Re: Quik Trip 7001 Unser and I-40 – Traffic Study Comments and Access

Re: Quik Trip Store # 7001
521 Unser Blvd. NW
Conceptual Traffic Circulation Layout for DFT Approval
Engineer's Stamp 05-31-24 (K10-D071)

SHEET NUMBER:
C100
05 OF 25

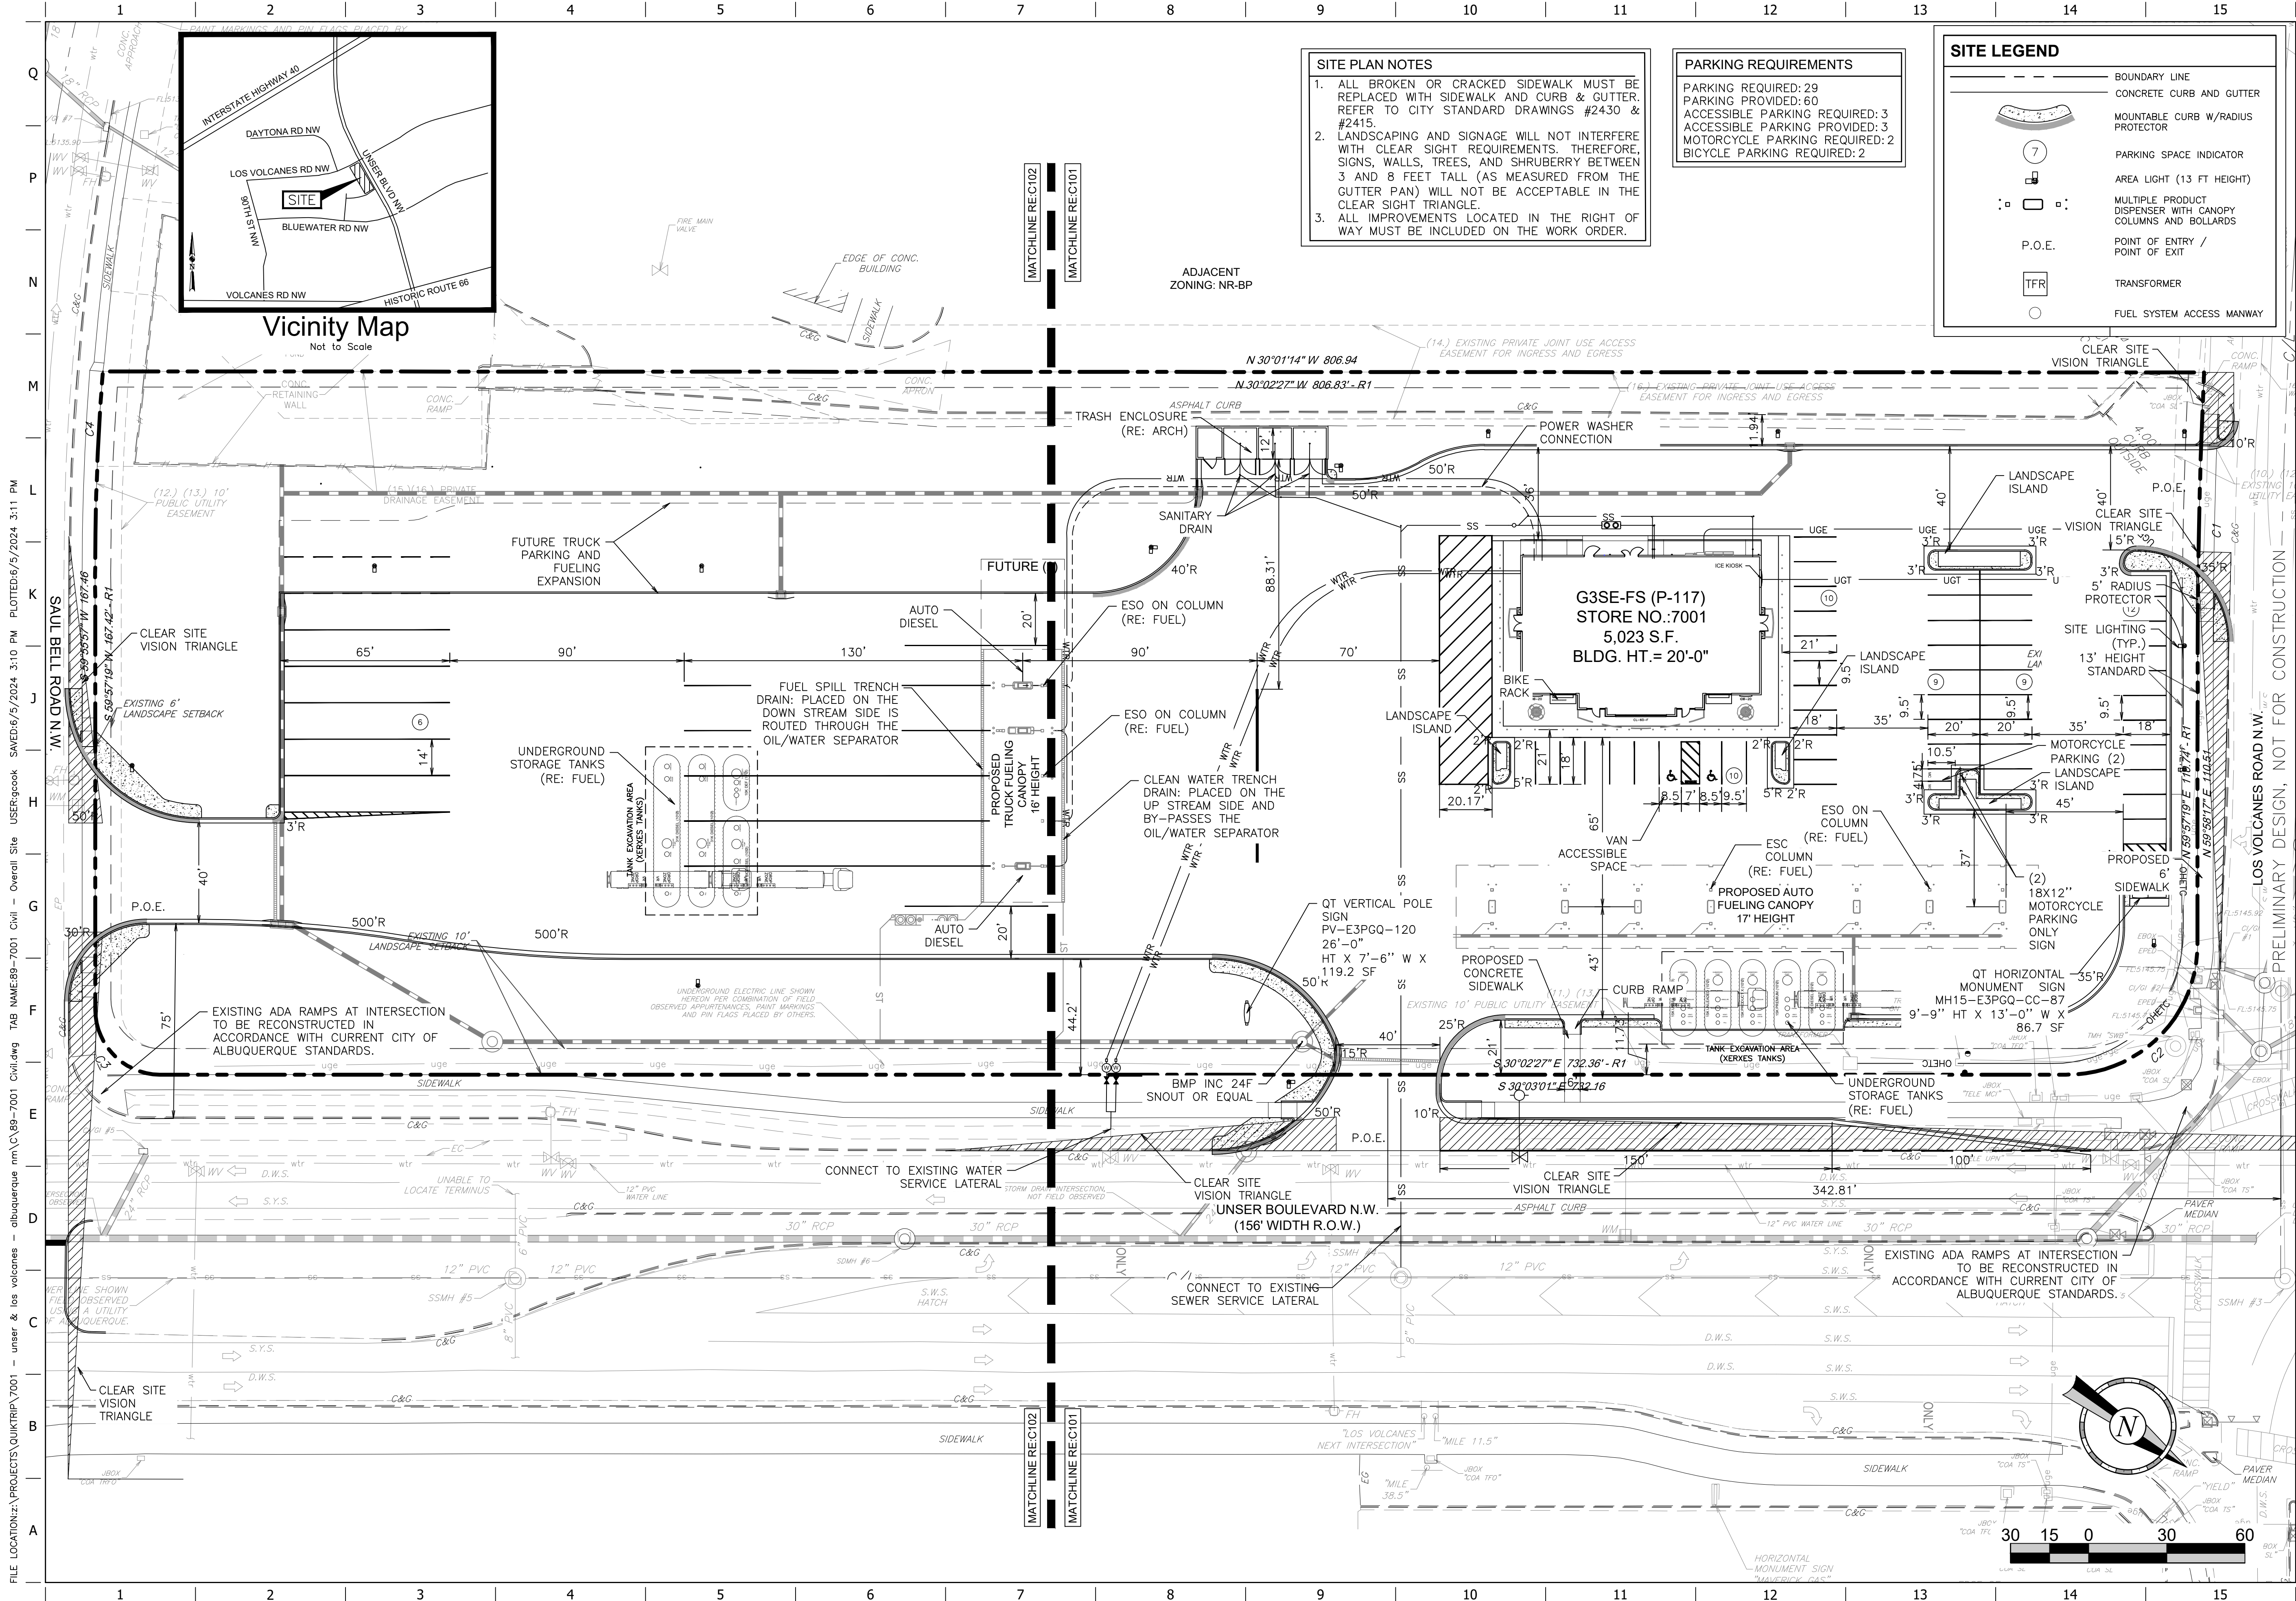
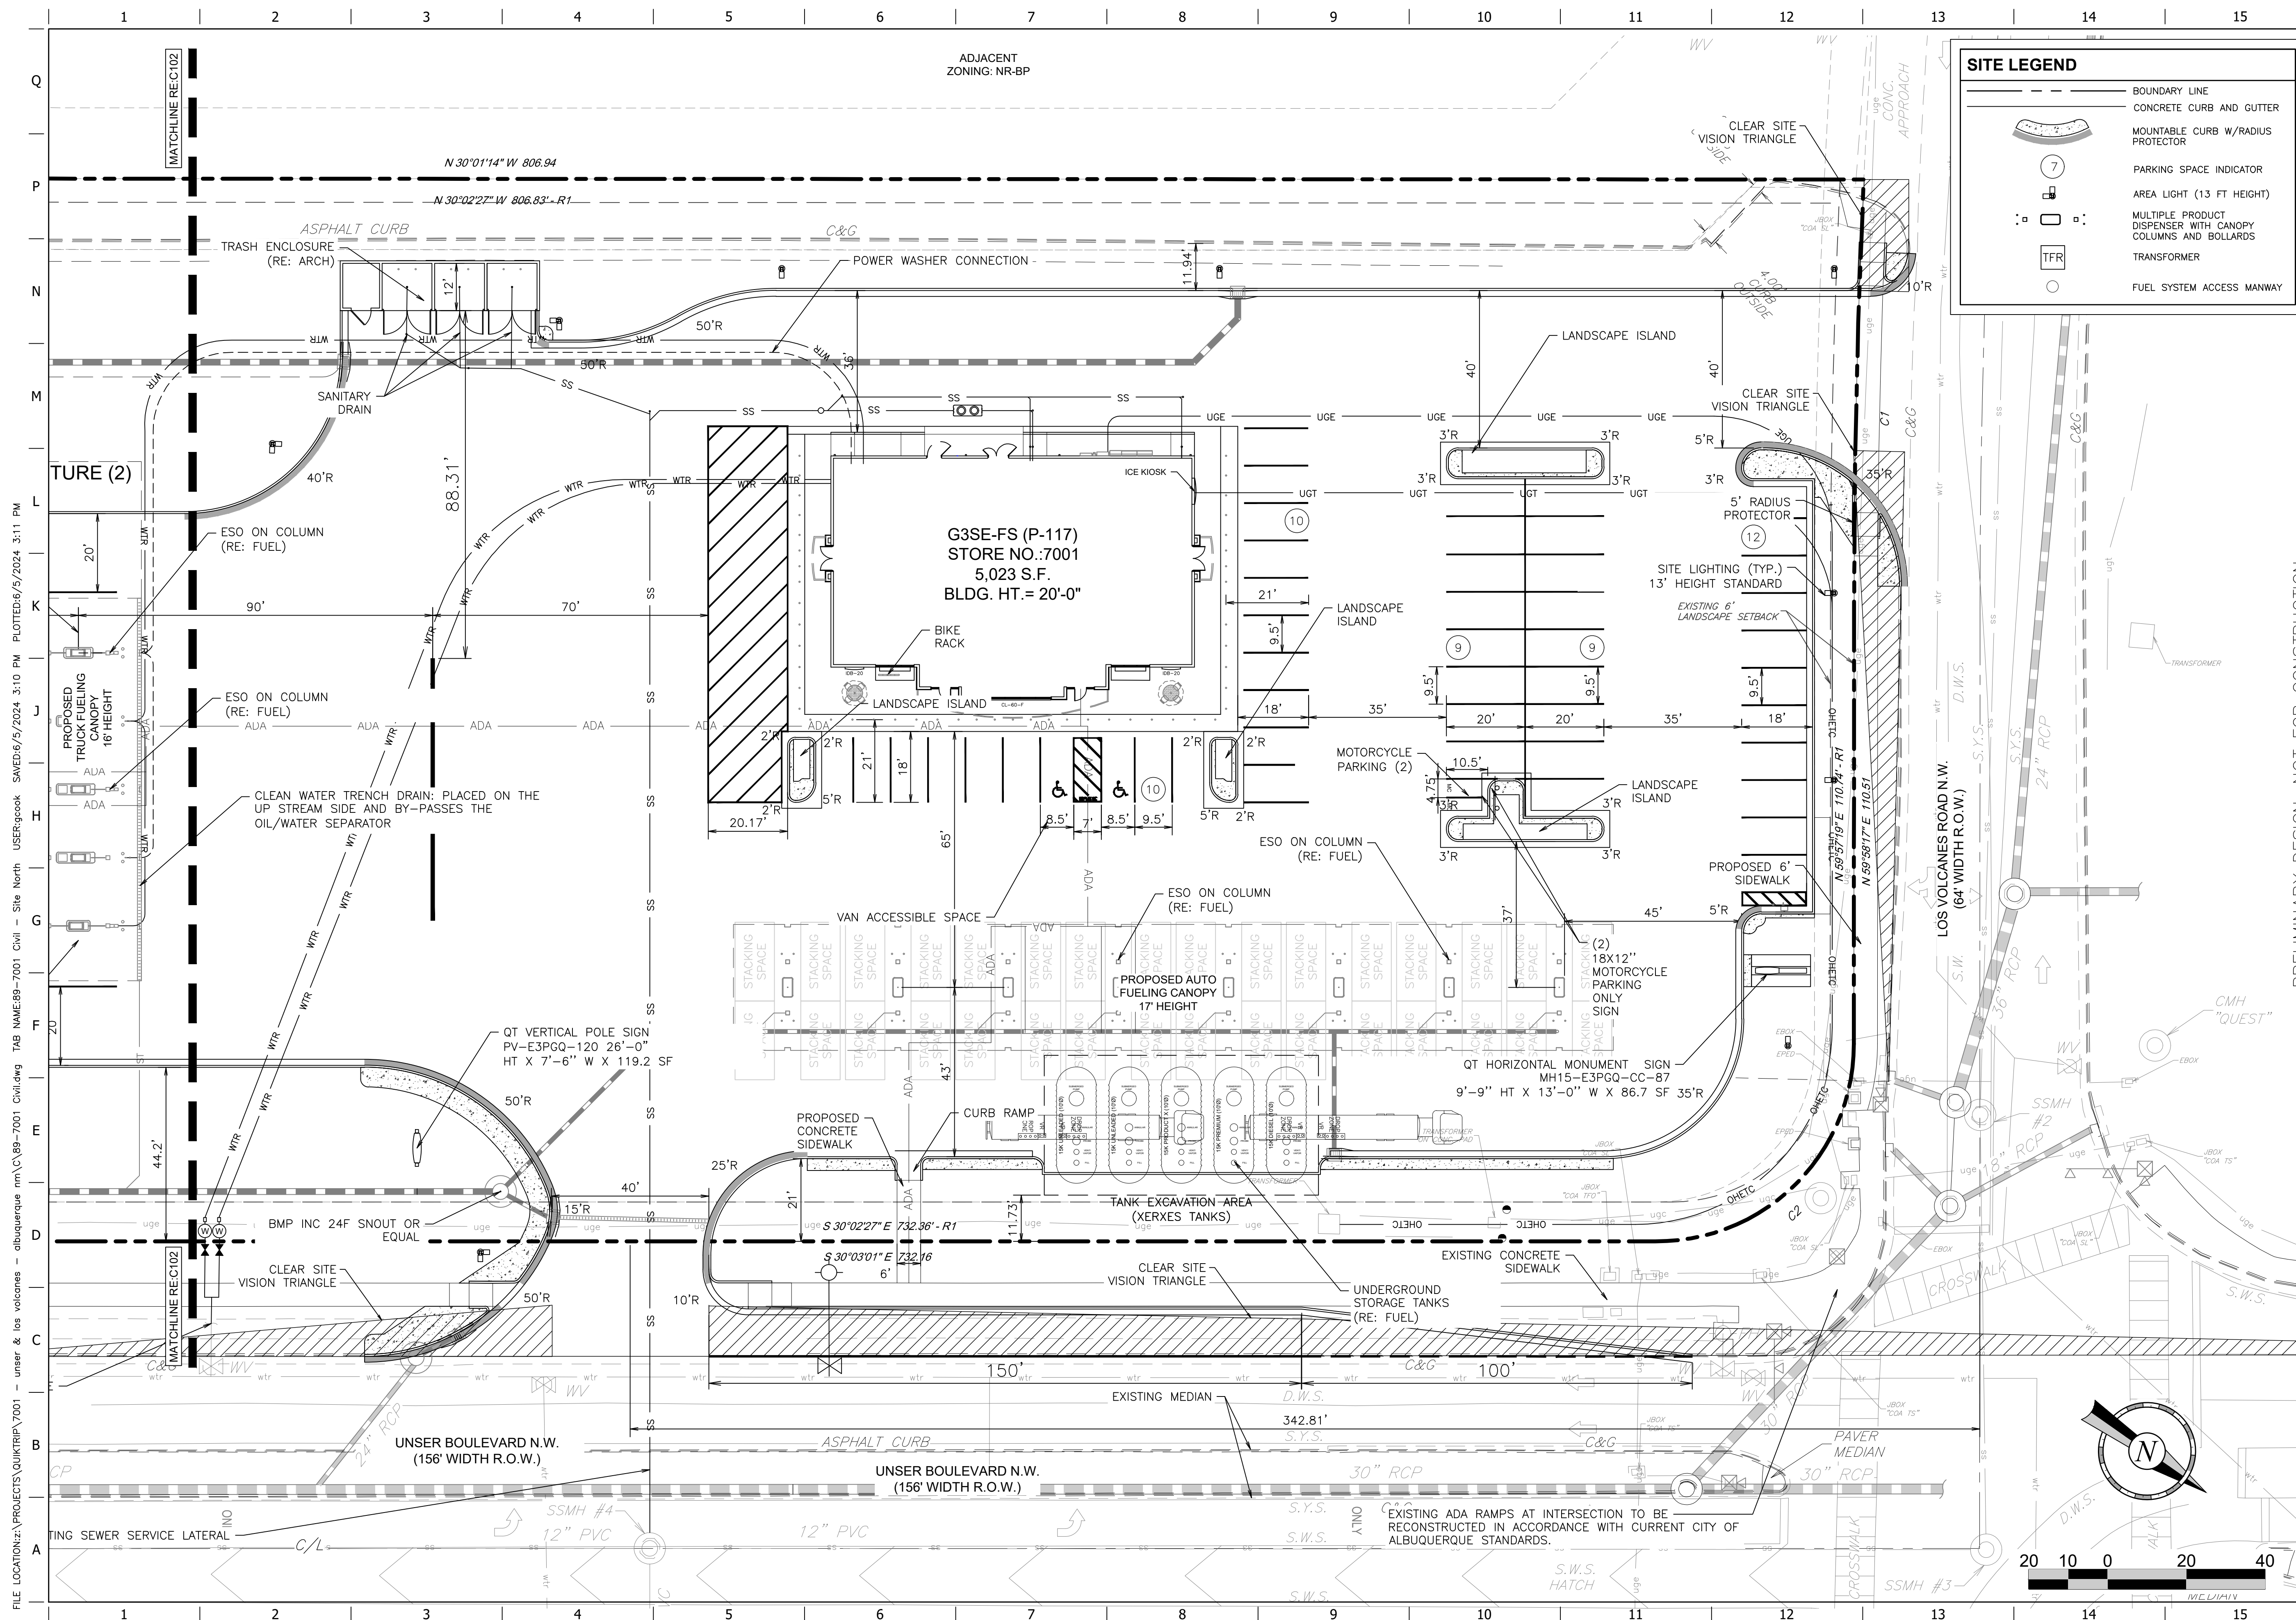
1. **An approved TIS must be provided.**
2. **Sheet C100: ADA parking aisle width should be minimum 8 ft.**
3. **Sheet details C510: ADA parking spaces width should be minimum 8.5 ft.**
4. **The minimum ADA pathway from the ADA parking aisle to the building entrance should be 6 ft. please show this dimension on the site plan.**
